158 Grant St.

**Amendment to Plan - 158 Grant Street**

**Subject:** Application ID: 2008-0148

RE: 158 Grant St., Four-unit Multifamily  
CBL: 053 C010001

CLIENT		158 GRANT STREET PORTLAND, MAINE	
		MISC. DETAILS 4 UNIT CONVERSION	
DATE	BY	SCALE	DATE
8/17/05	SNS	AS NOTED	07-30-04
4/15/05	SNS		
8/08/04	SNS		
DRAWING NUMBER		A-6

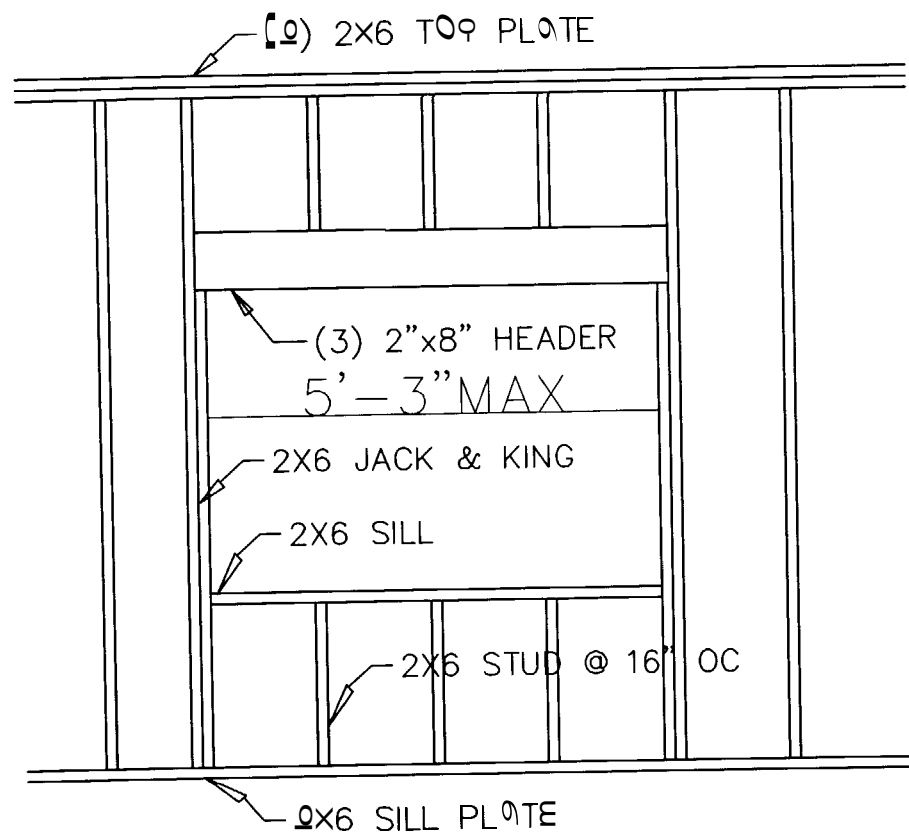
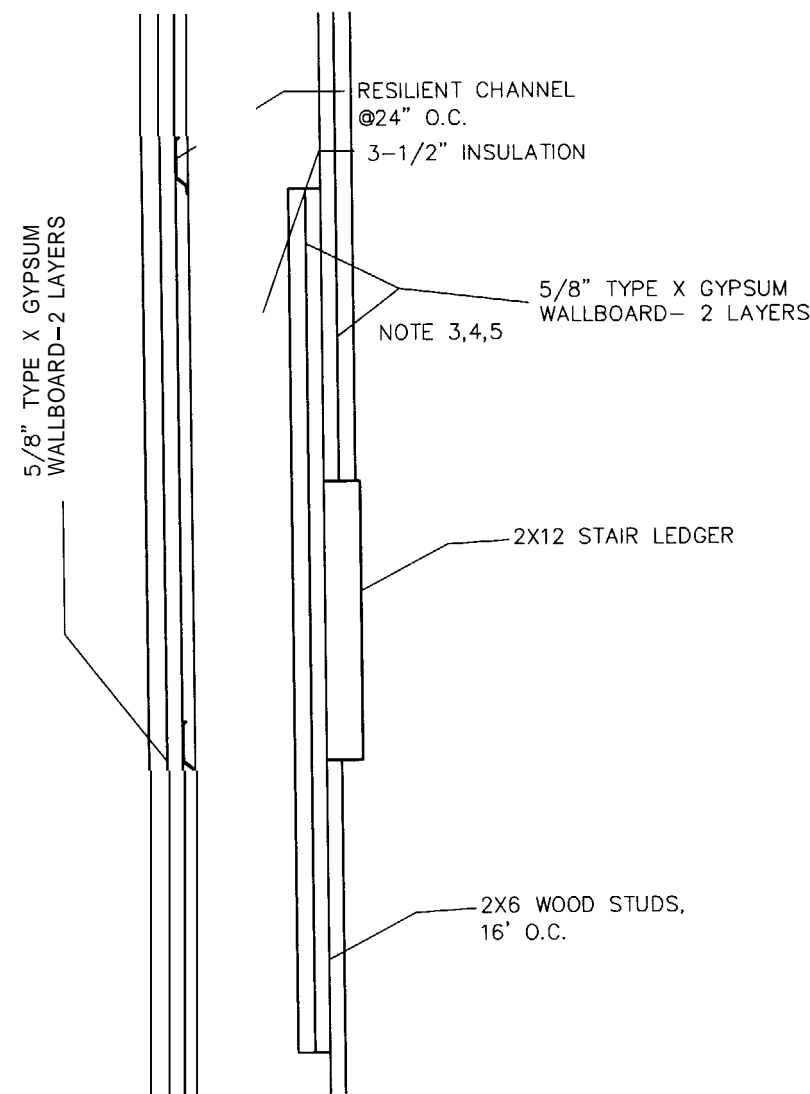
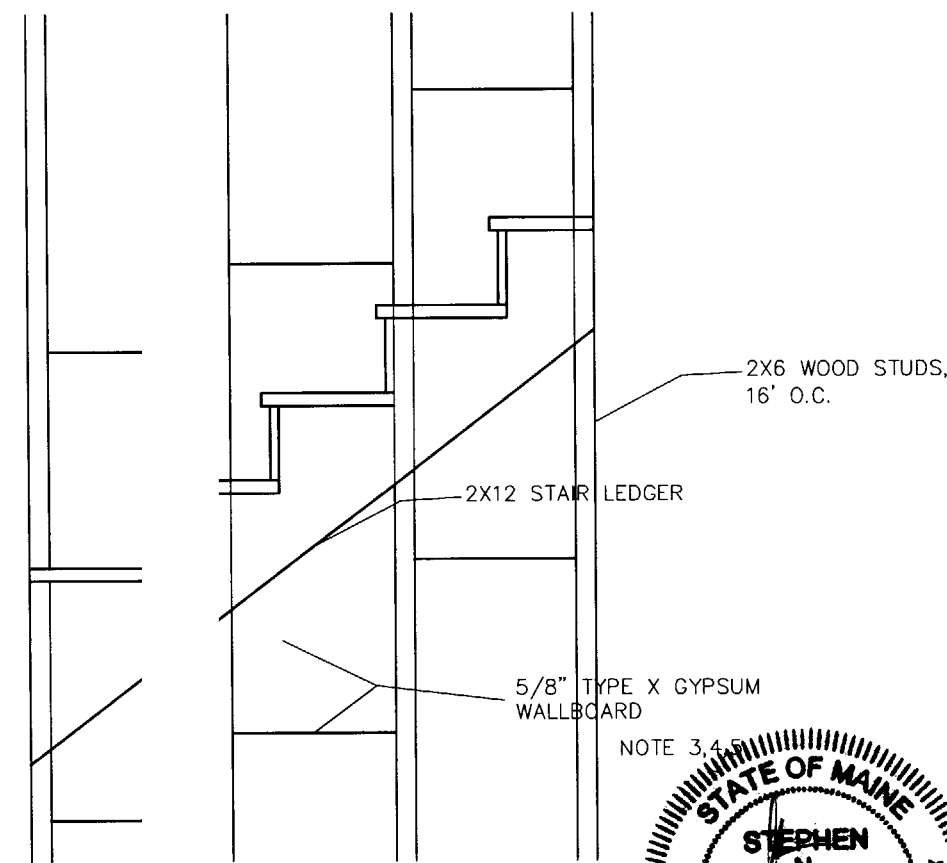
A sprinkler system approved by the State Fire Marshalls office is required

\* My proposal does not include a sprinkler system as the fire walls are proposed as such that the structure on each side of the wall may be considered a separate building for the purposes of building code evaluation. Please reference Misc. Details page outlining "typical floor-ceiling system 2 hour fire and stc 50 sound rating" and "typical firewall system 2 hour fire and stc 50 sound rating" which should outline the fire rating system proposed and eliminate the need for a sprinkler system

CLIENT	158 GRANT STREET PORTLAND, MAINE		
	SITE PLAN 4 UNIT CONVERSION		
DRAWN BY:	SMS	SCALE:	AS NOTED
DATE:	07-15-04		
DRAWING NUMBER	F-1

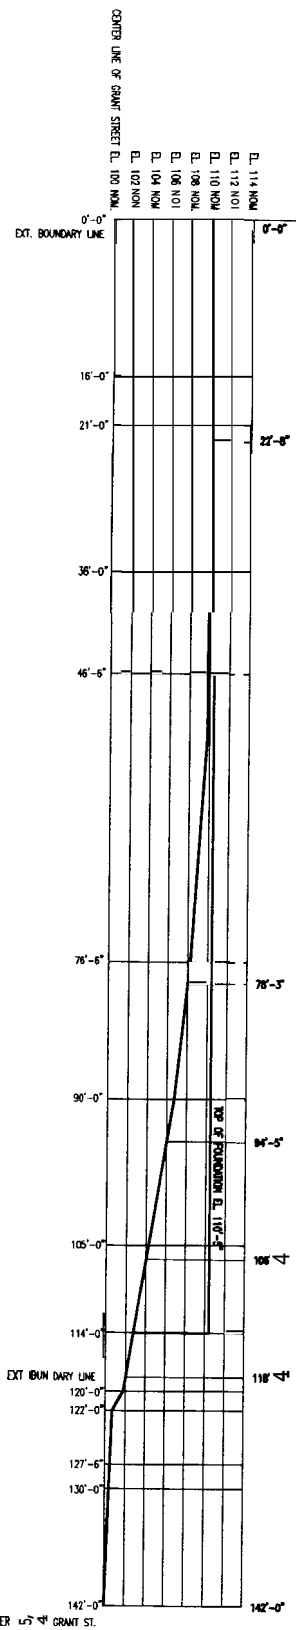
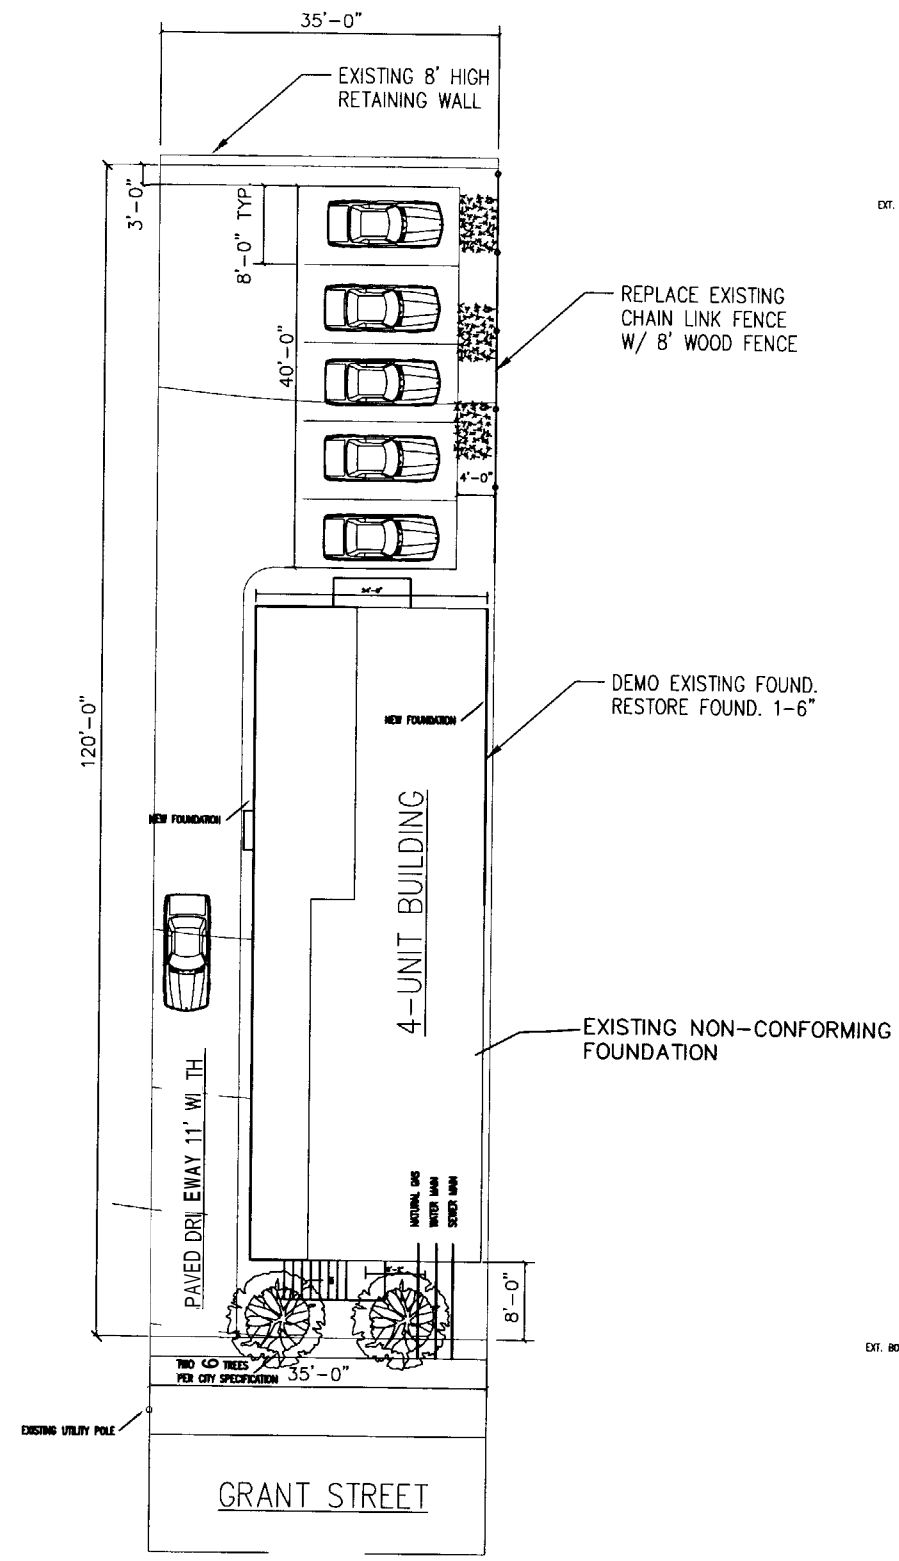
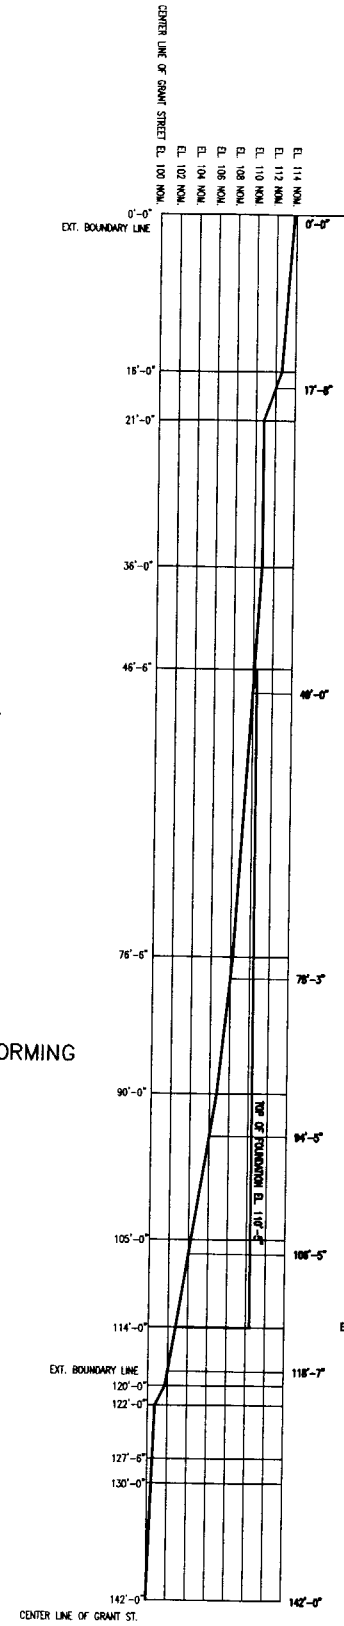
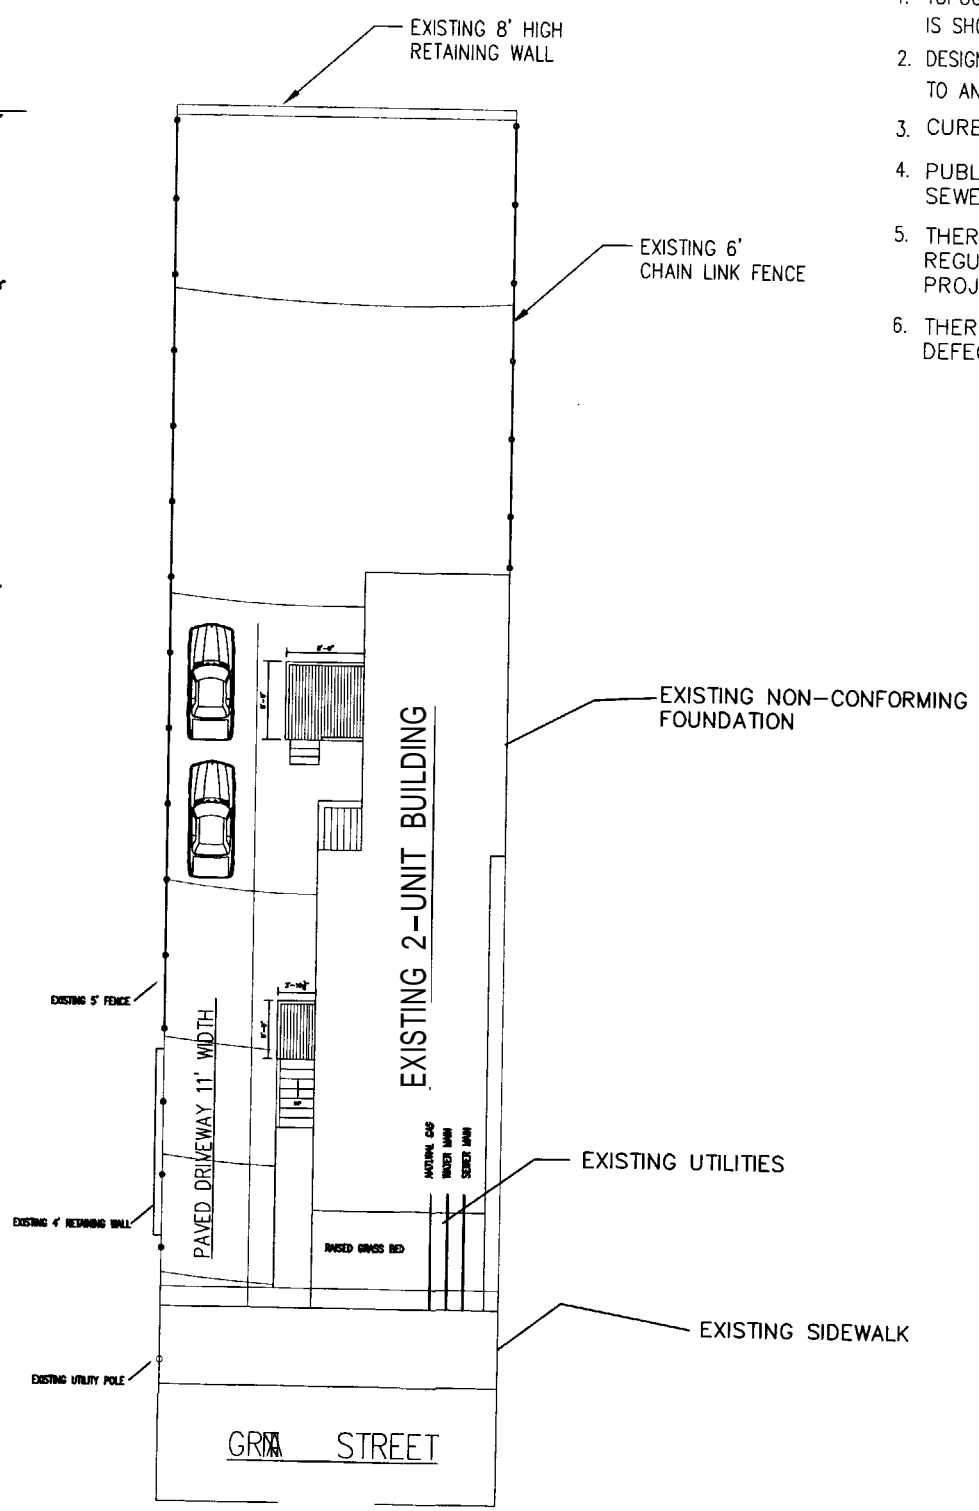
➤ The details of the erosion and sedimentation control plan discuss control measures for the development of 10 lots on Spurwink Road in Scarborough, ME. Please revise include measures for 158 Grant St.

3. While the site plan does reference another project, the plan was submitted for reference only. The intent was to provide standards and practices to be used, as detailed in the Maine Erosion and Sedimentation Control Handbook: Best Management Practices. Most of the heavy construction/site work has already been done, with just fine grading/clean up outstanding. Any further site work follow the standards shown on the Erosion & Sedimentation Control Notes and Details page of the site plan.
